## Grandview Reserve Master Development Drainage Plan

September 2020

**Engineering Review**

**EPC Planning & Community  
Development Department**

EXISTING EX1

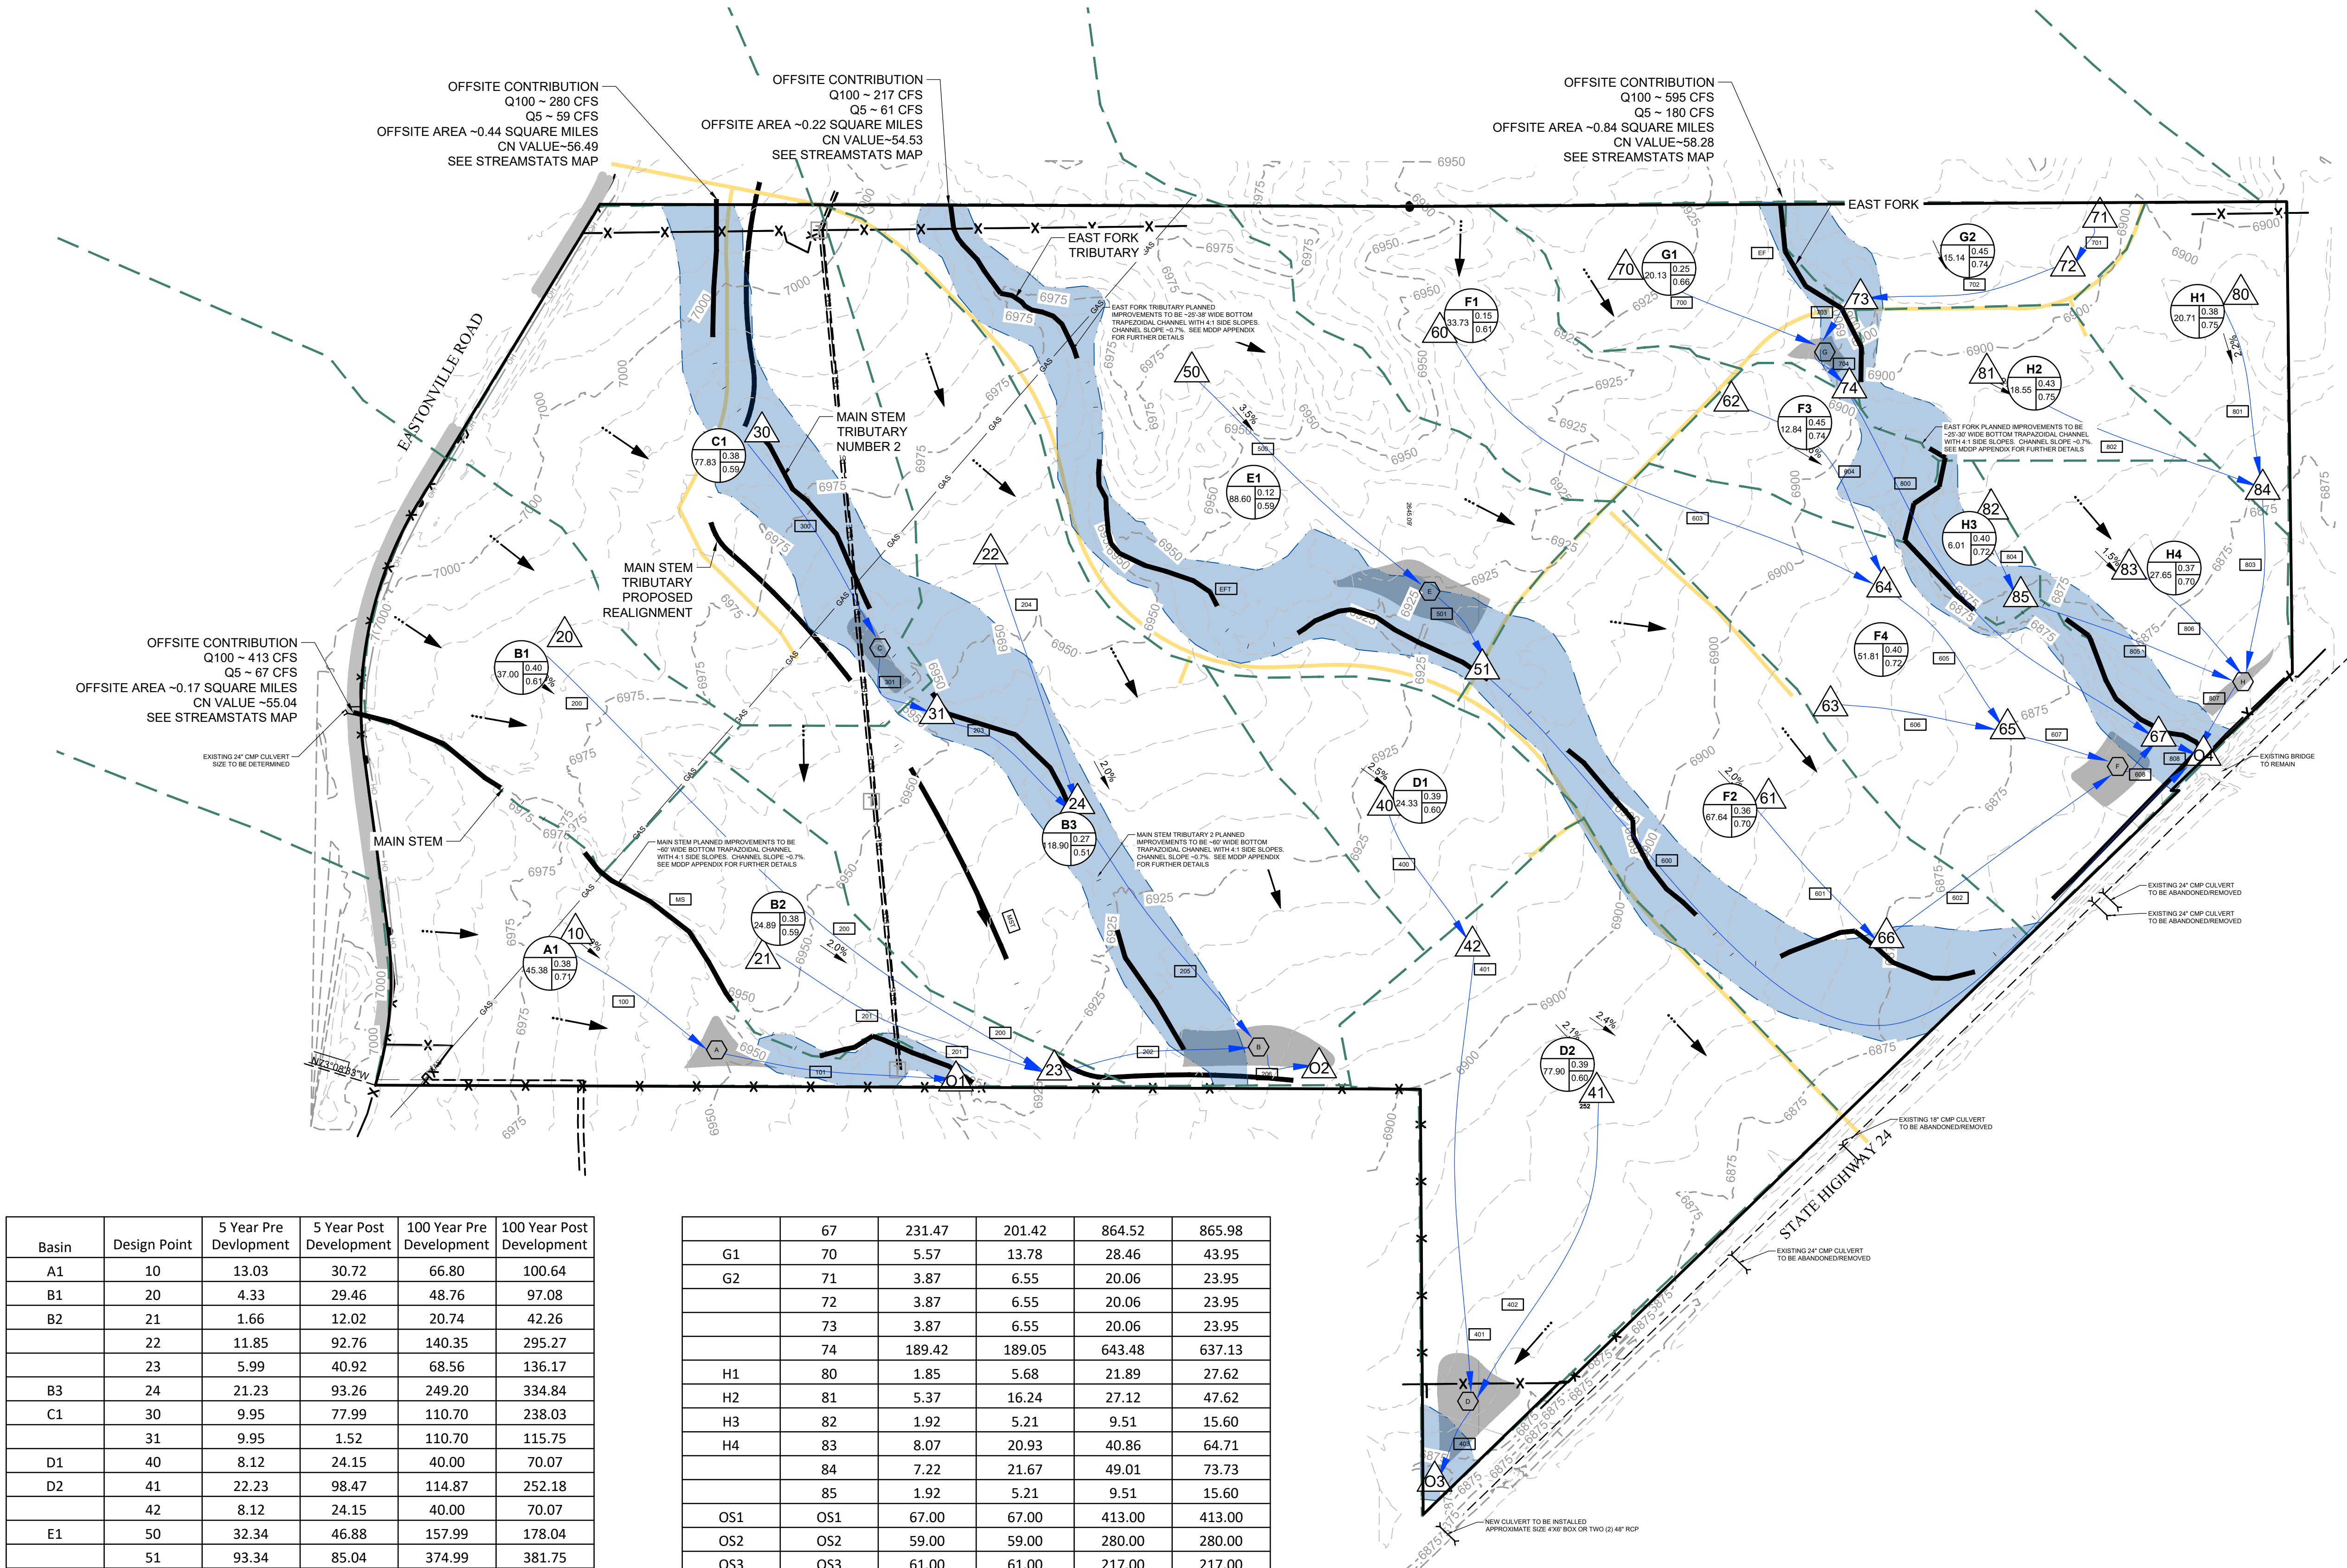
These should be the total flows, including offsite flows. Add an additional column, reach flow tables or combined DP tables if necessary or add a note that the onsite DPs are only onsite flows.

These should be the total flows, including offsite flows. Add an additional column, reach flow tables or combined DP tables if necessary or add a note that the onsite DPs are only onsite flows.

PROPOSED DR1

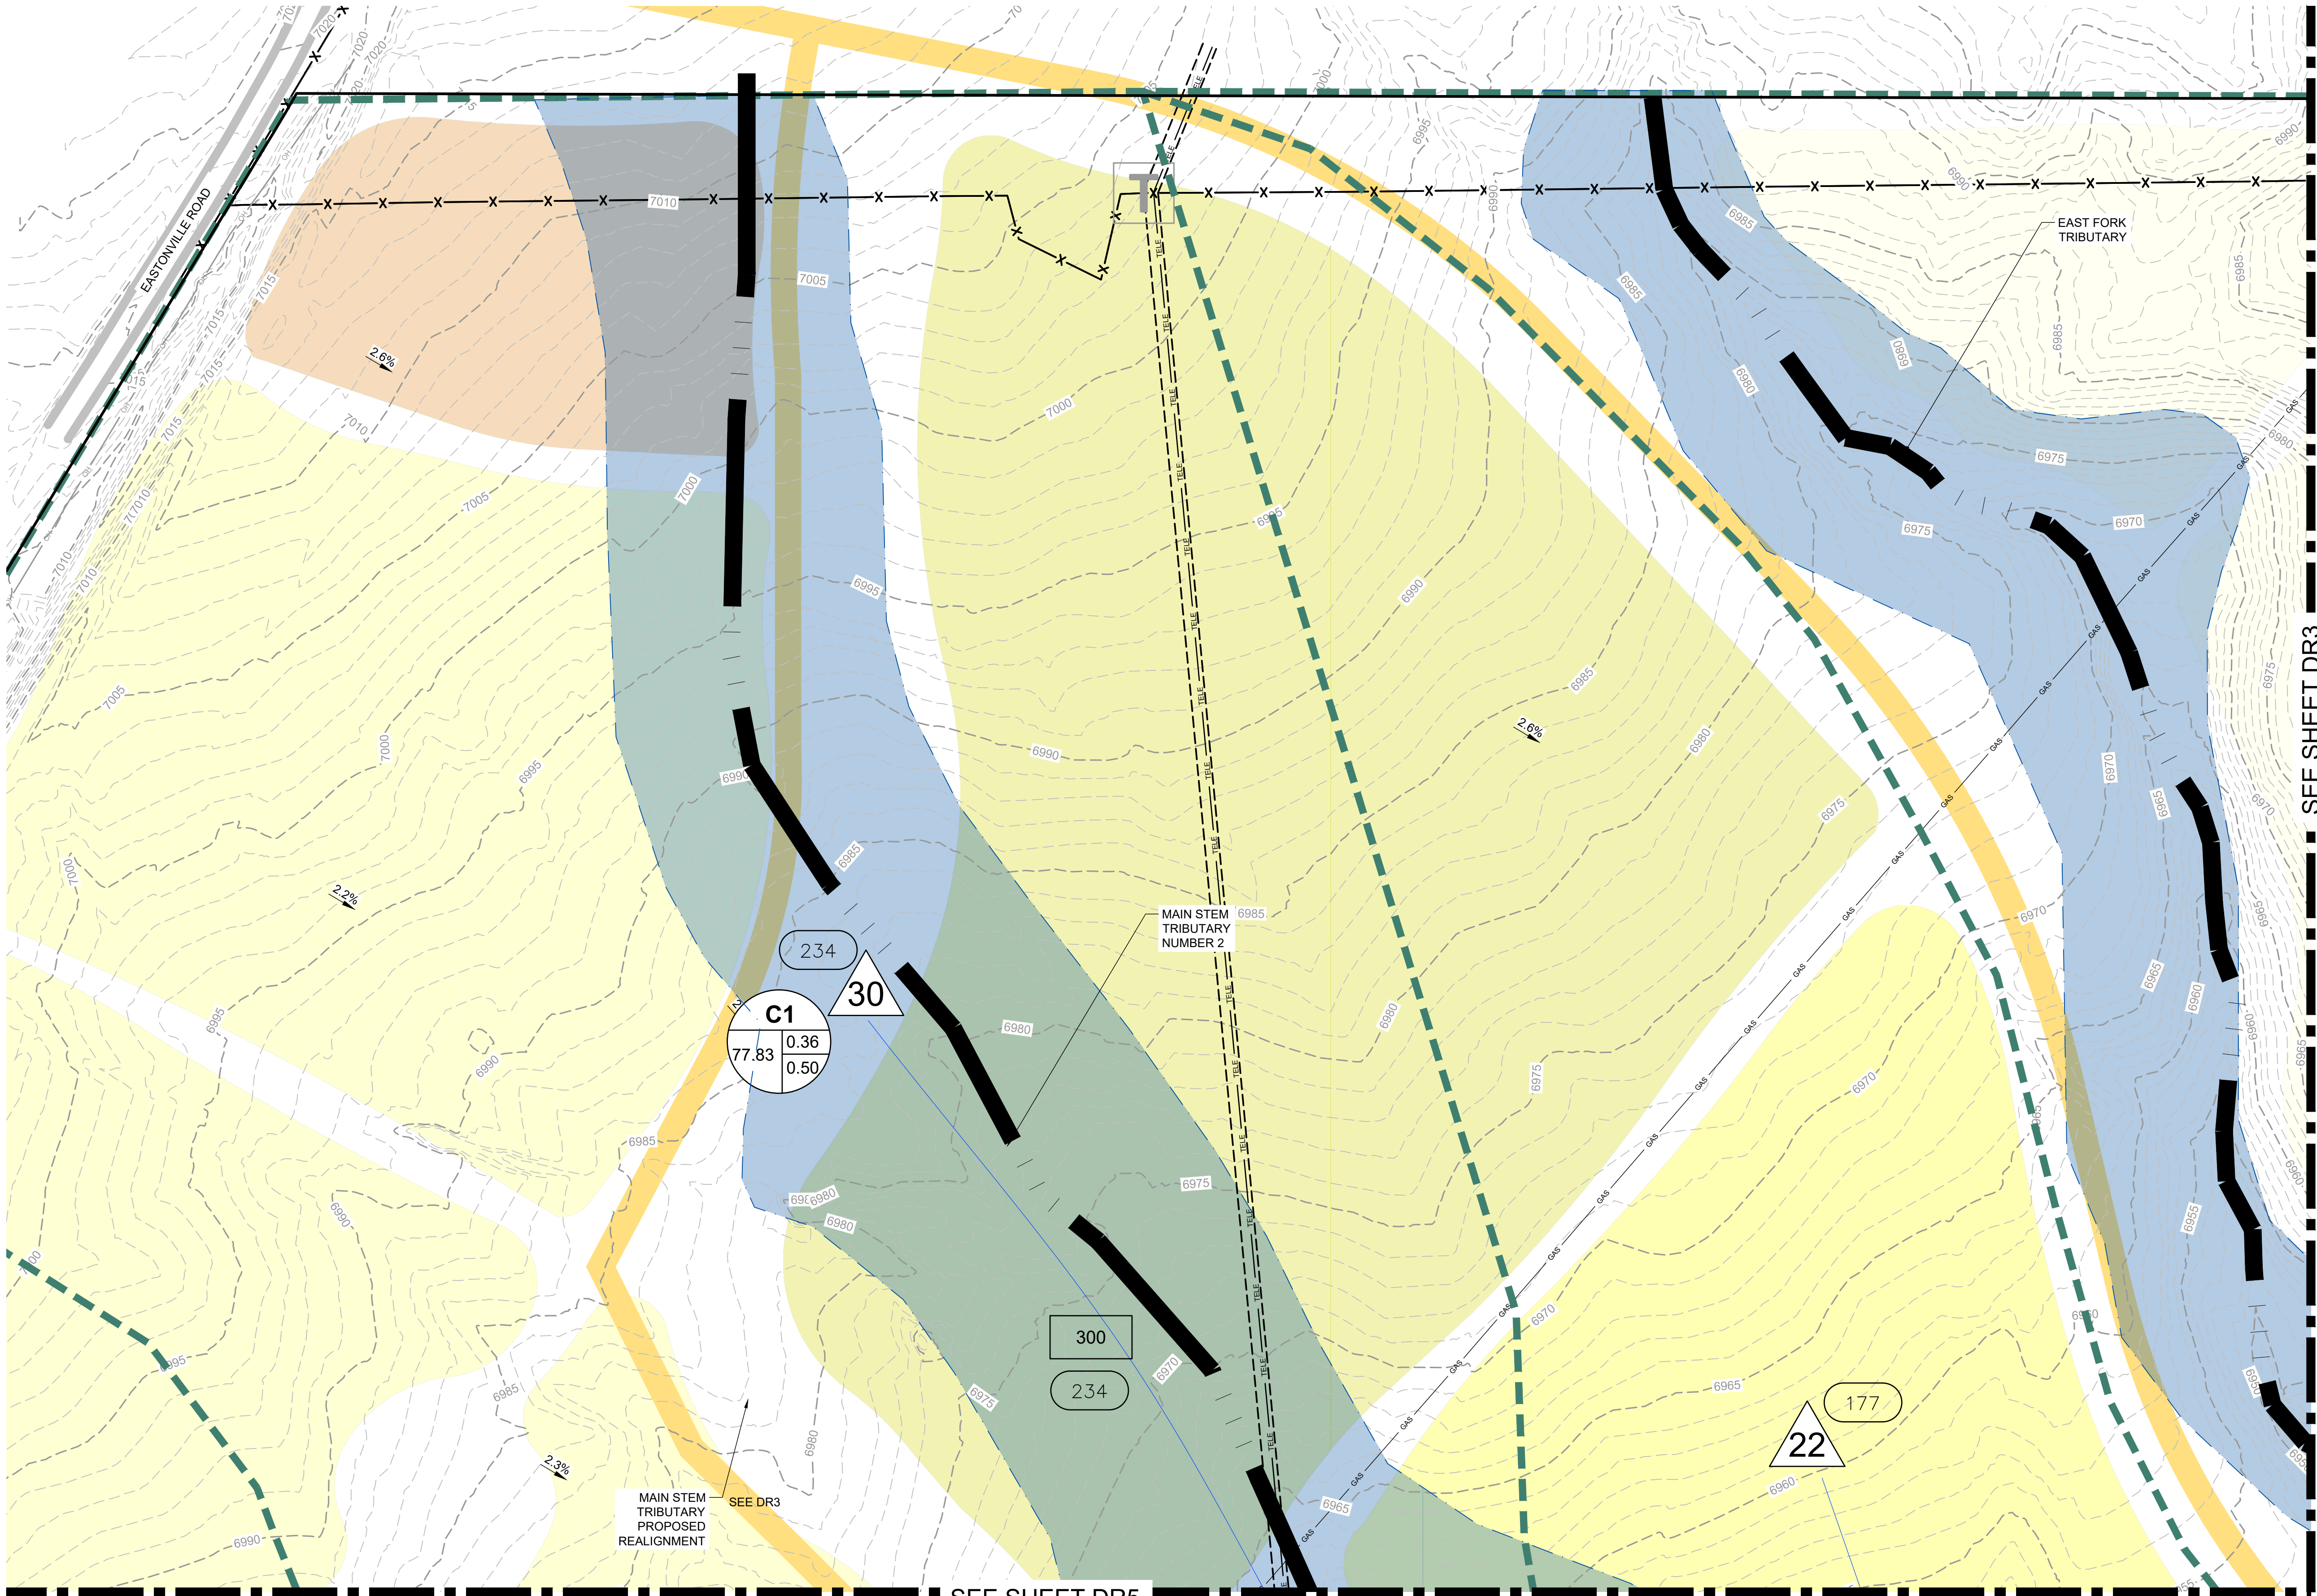
This is > than existing of 154. Add a note or footnote that it will be adjusted to meet criteria with the Preliminary Drainage Report.
